Application for certificate of lawfulness for a proposed use of Former Ford Blockworks
Hangar No. 2 for use Class B2 (General Industrial)
Former Ford Blockworks (Hangar No. 2) Ford Airfield Industrial Estate Ford

Thank you for your internet representation made on 19th July 2013 which has been recorded as '**an objection**' with the comments as follows:

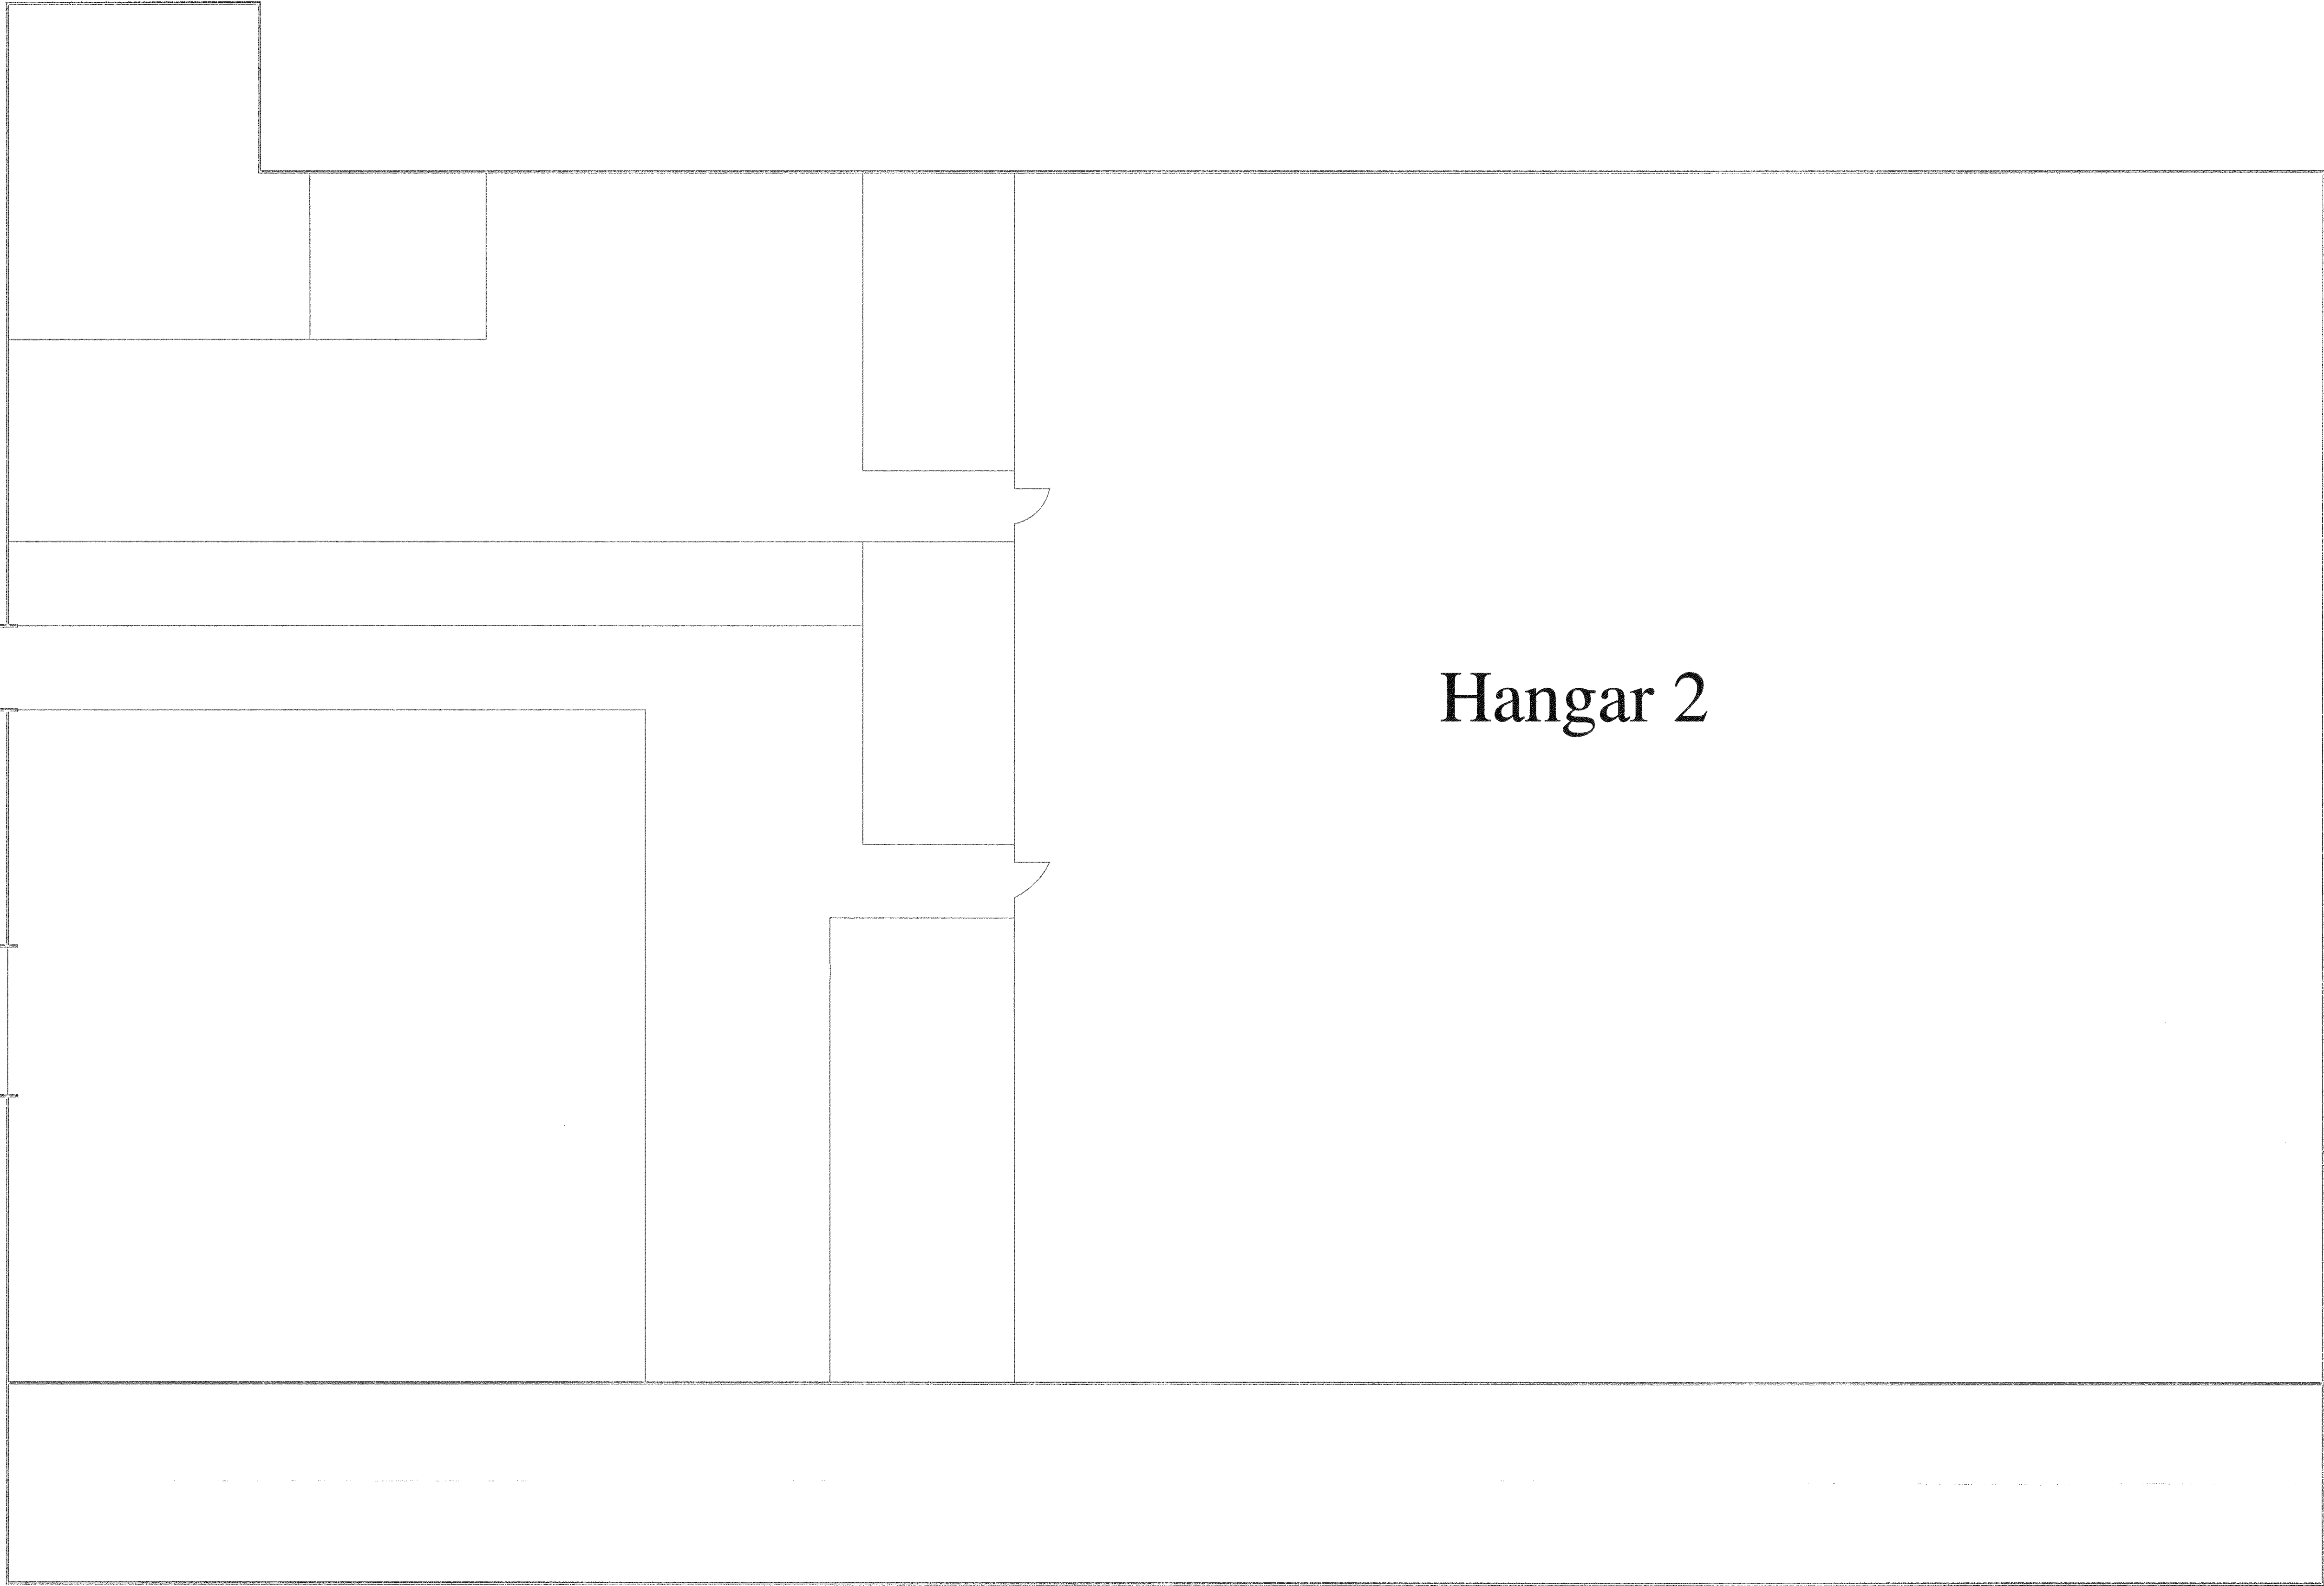
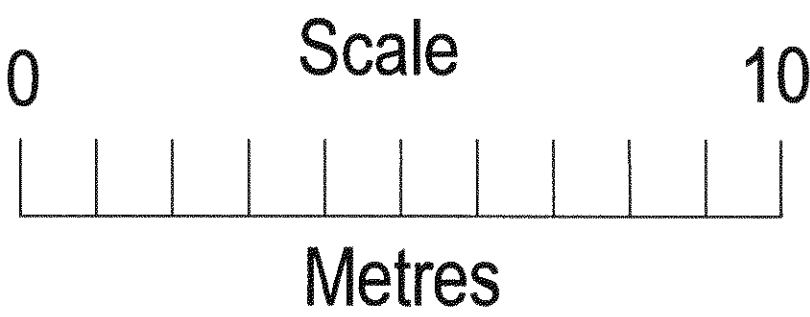
Drawing required in scale 1:50 whereas the drawing delivered is 1:100.
